Application No: EP/57/20/HH
Site Address: 32 Vermont Drive East Preston West Sussex BN16 1LA
Description of works: Loft conversion with side dormer and hip to gable extension to rear.

Thank you for your internet representation made on 23rd June 2020 which has been recorded as an objection with the comments as follows:

PROPOSED REAR ELEVATION (1:100)

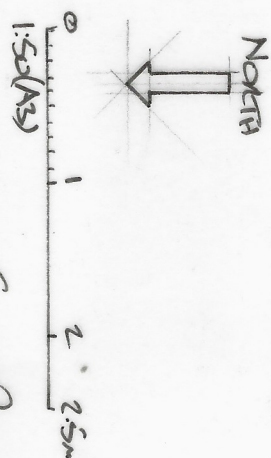
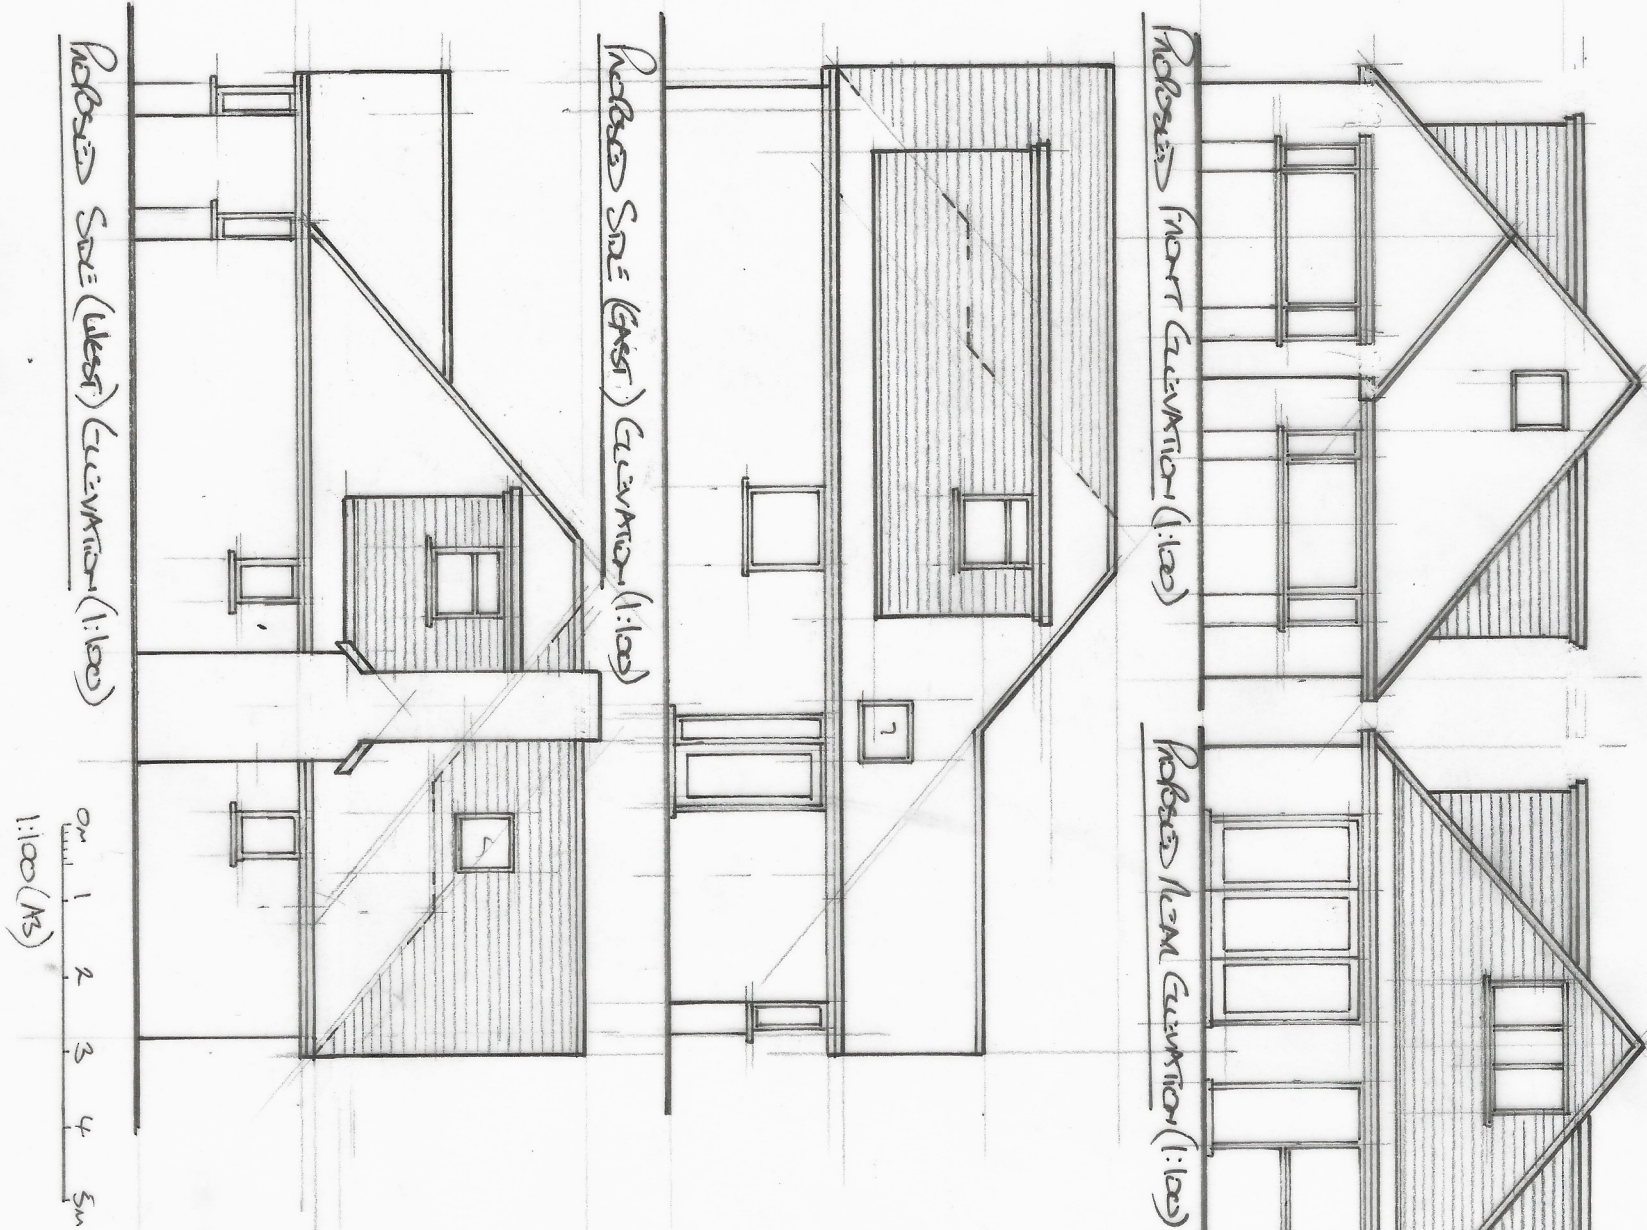
After looking at the plans, the Windows on this extension will reduce my privacy in my garden and my lounge as the whole of the back of my property has glass bi-fold doors
